TfNSW reference: REN25/00082/009

Your reference: SSD-52786213-Mod-1

SSD-52786213, Calala BESS, 474 Calala Lane, Calala; Modification Report,

TfNSW has reviewed the Modification Report prepared by Tract dated 25 September 2025 and Traffic Impact Assessment (TIA) prepared by Stantec Australia dated 22 September 2025, as key documents for preparing this response.

DRAWING NO. 300304168-04-01 SHEET 01 OF 05

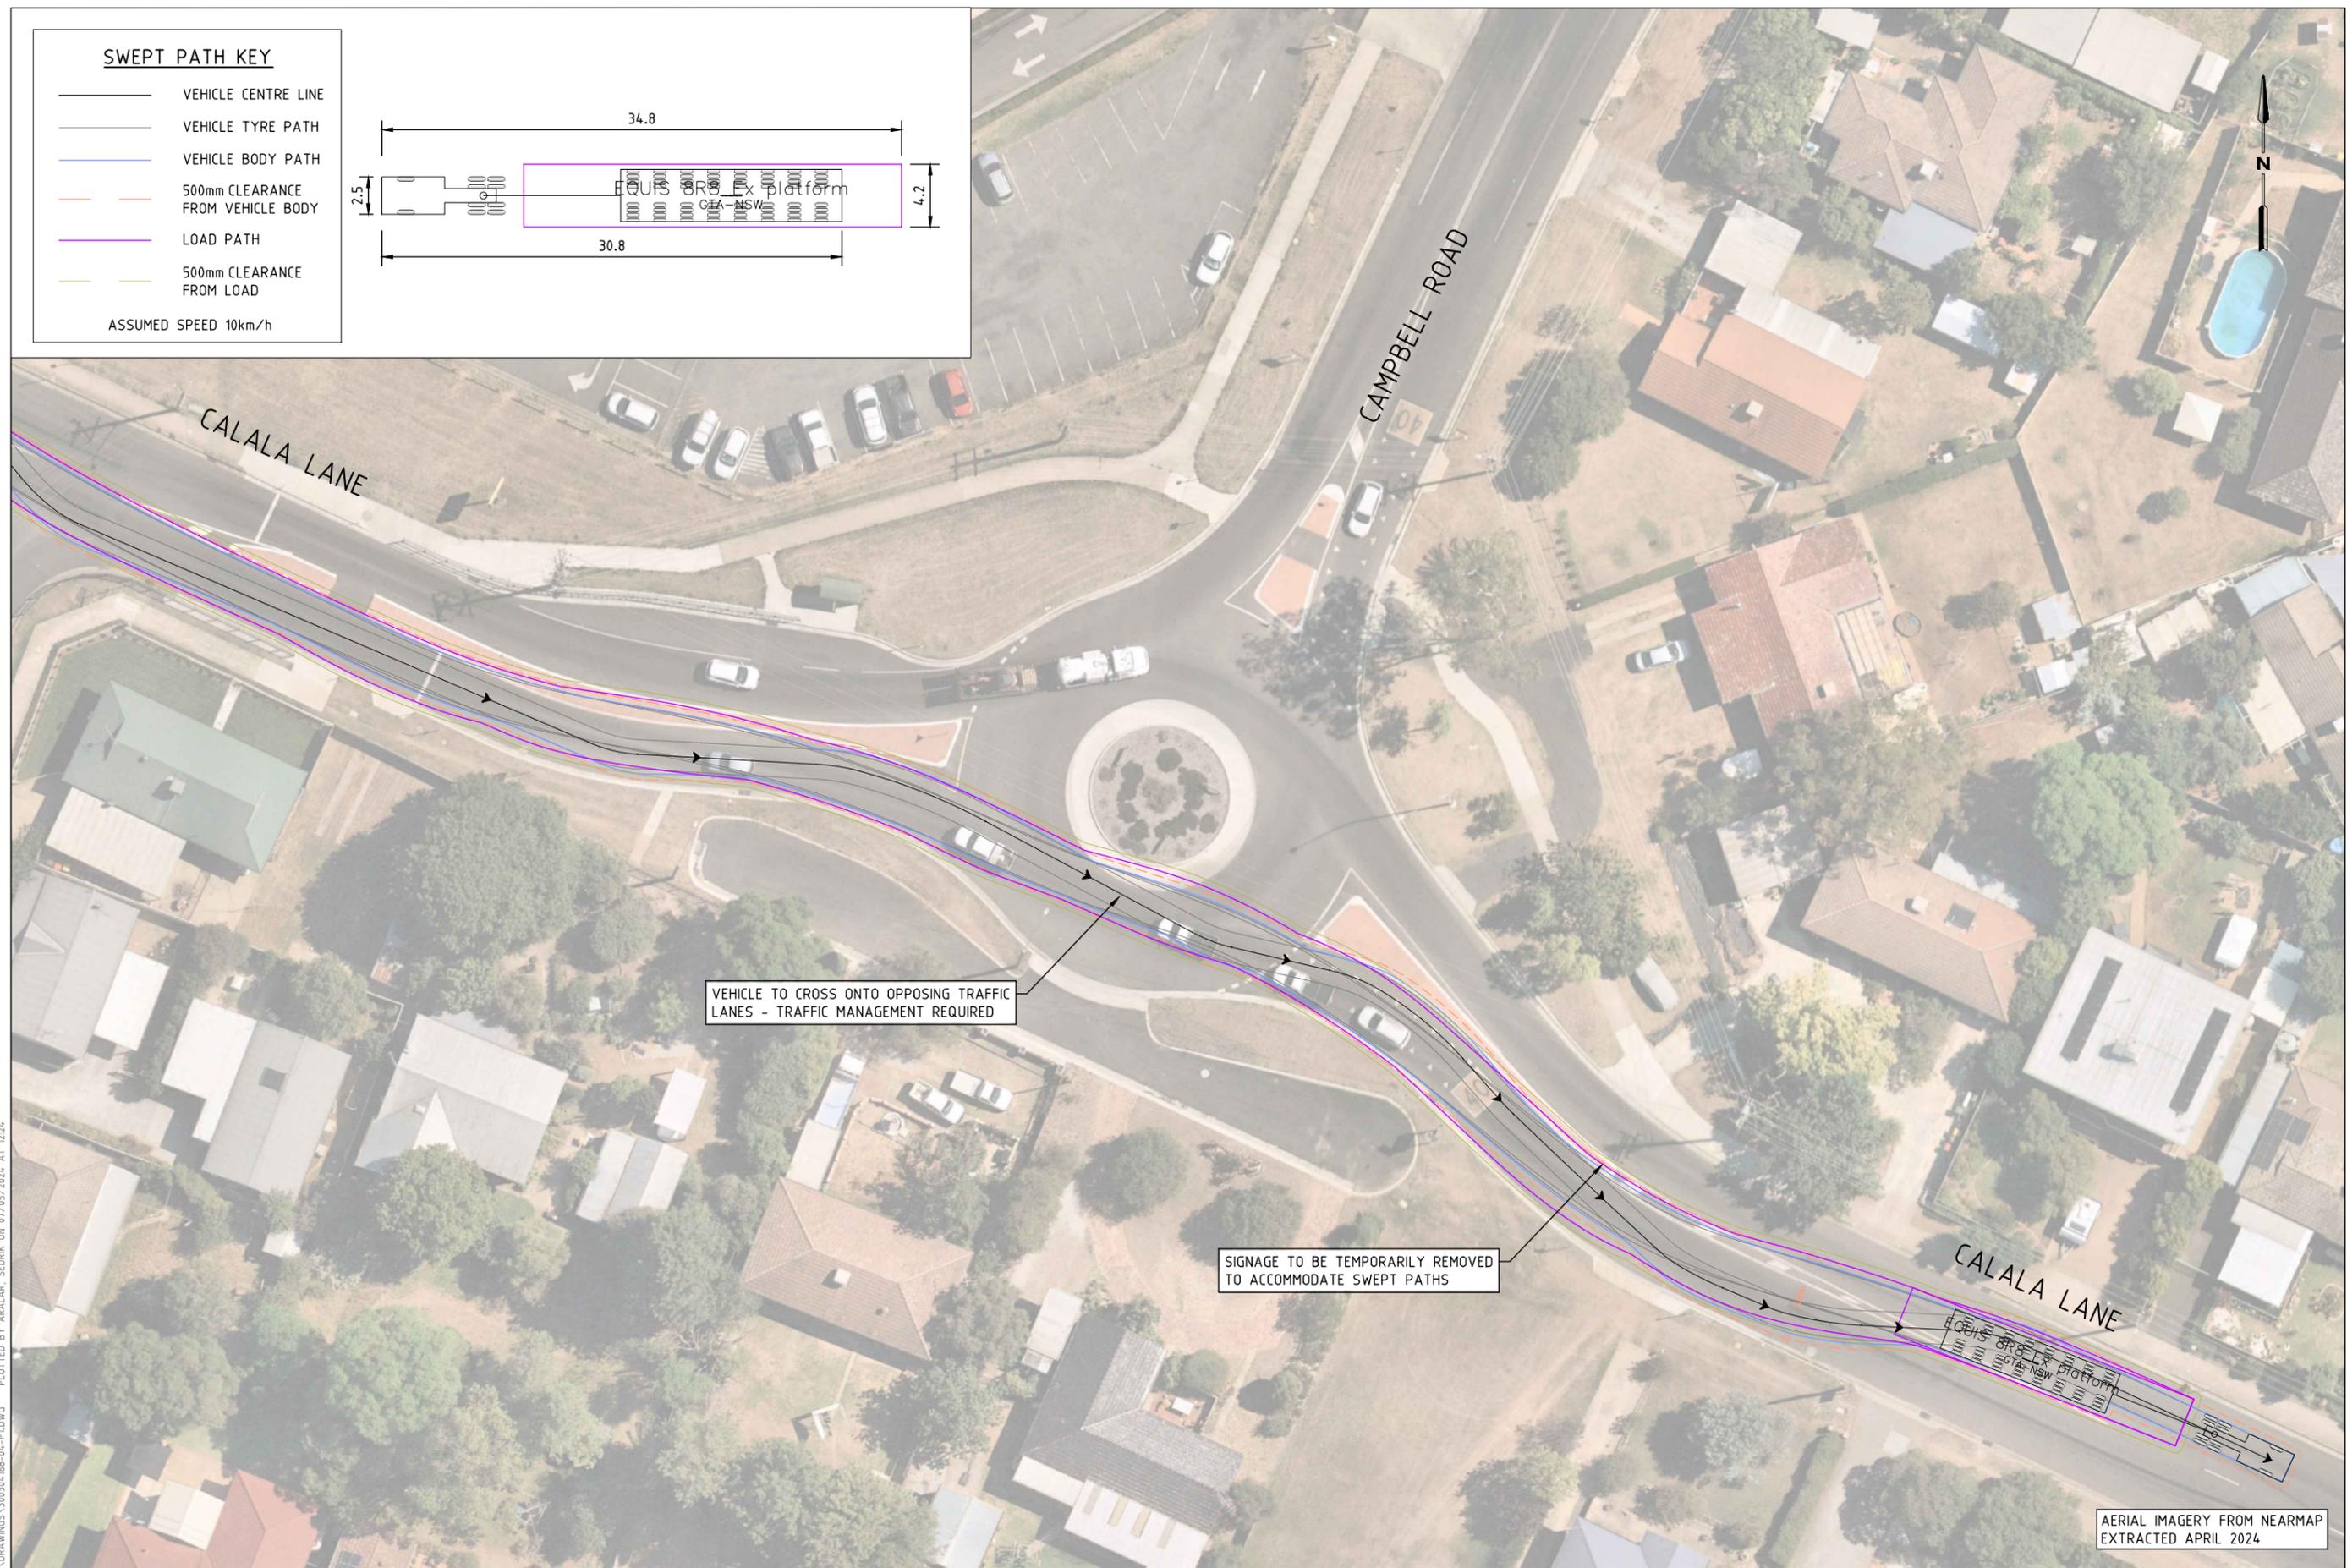
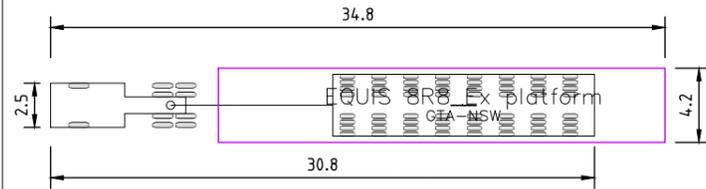
No.	TfNSW additional information requested to address outs
1.	The swept path analysis indicates that concurrent turning of the B-double at Goonoo Goonoo Road/Burgmans Lane is not achievable. The TIA is to be updated to explain that mitigation measures will be implemented to prevent concurrent turn movements by construction traffic B-double heavy vehicles at the intersection of Goonoo Goonoo Road/Burgmann's Lane.
